**Subject:** SP-26-00008 Thorp Landing - Notice of Application

**RE: ECY 202603780; SP-26-00008**

Fire Marshal comments  
Thorp Landing  
SP-26-00008

**TO:** All Staff  
**FROM:** Public Works Plan Review Team  
**DATE:** September 18, 2026  
**SUBJECT:** SP-26-00008 Thorp Landing

THORP LANDING SHORT PLAT NO. 1 PART OF SECTION 11, T. 18 N., R. 17 E., W.M. KITTITAS COUNTY, WASHINGTON

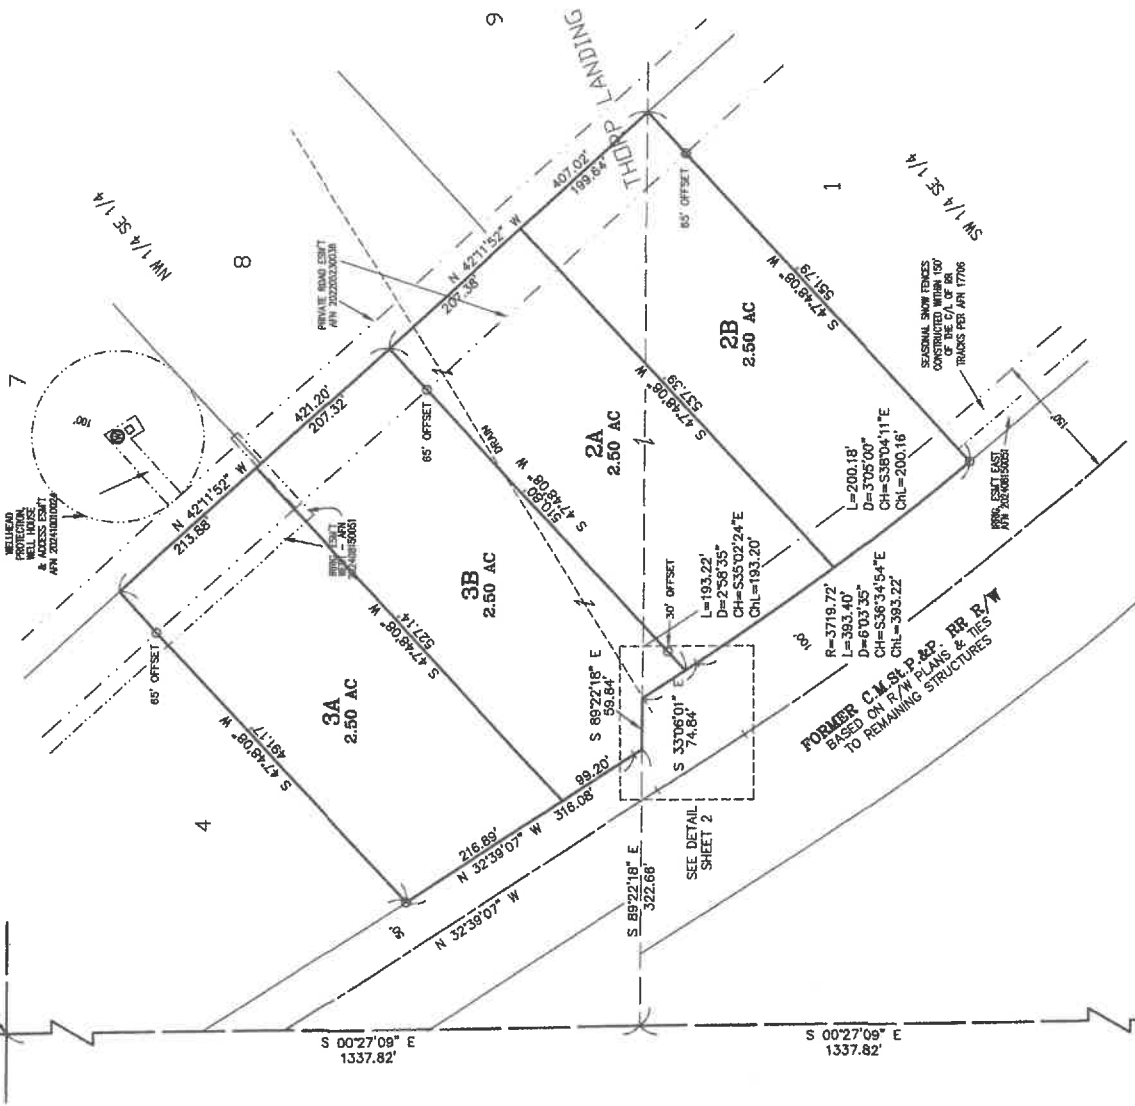
| <b>Drinking Water</b> | <ul style="list-style-type: none"><li>• The application narrative states that proposed Lots 2A, 2B, 3A, and 3B will each be served by an individual well or shared well. However, the preliminary survey identifies the source of water as a Group B Water System. Please clarify the proposed water supply for each resulting lot.</li><li>• The existing Thorp Landing Group B water system was approved for six service connections. If the proposal is to remove the existing Lots 2 and 3 connections from the Group B system and provide separate individual or shared wells to the resulting lots, revised water-system documentation and approval may be required prior to approval of the short plat.</li><li>• Please provide a revised water plan identifying the proposed water source and service arrangement for Lots 2A, 2B, 3A, and 3B, including whether any of the existing Group B connections will be discontinued or relocated.</li></ul> |

Approved fire apparatus turnarounds are required for this project. The indicated provisions for turning around fire apparatus are not adequate. Provide an approved turnaround constructed in accordance with the International Fire Code Appendix D.

| <b>SURVEY</b>                     | Missing lot closures. Will wait for Final survey before reviewing. DF                                                                                                                                                                                                                                                                                                                                                                                                                                                                                                                                                                                                                                                                                                                                                                                                                                                                                                                                                                                                                                                                                                                                                                                                                                                                                                                                                                                      |
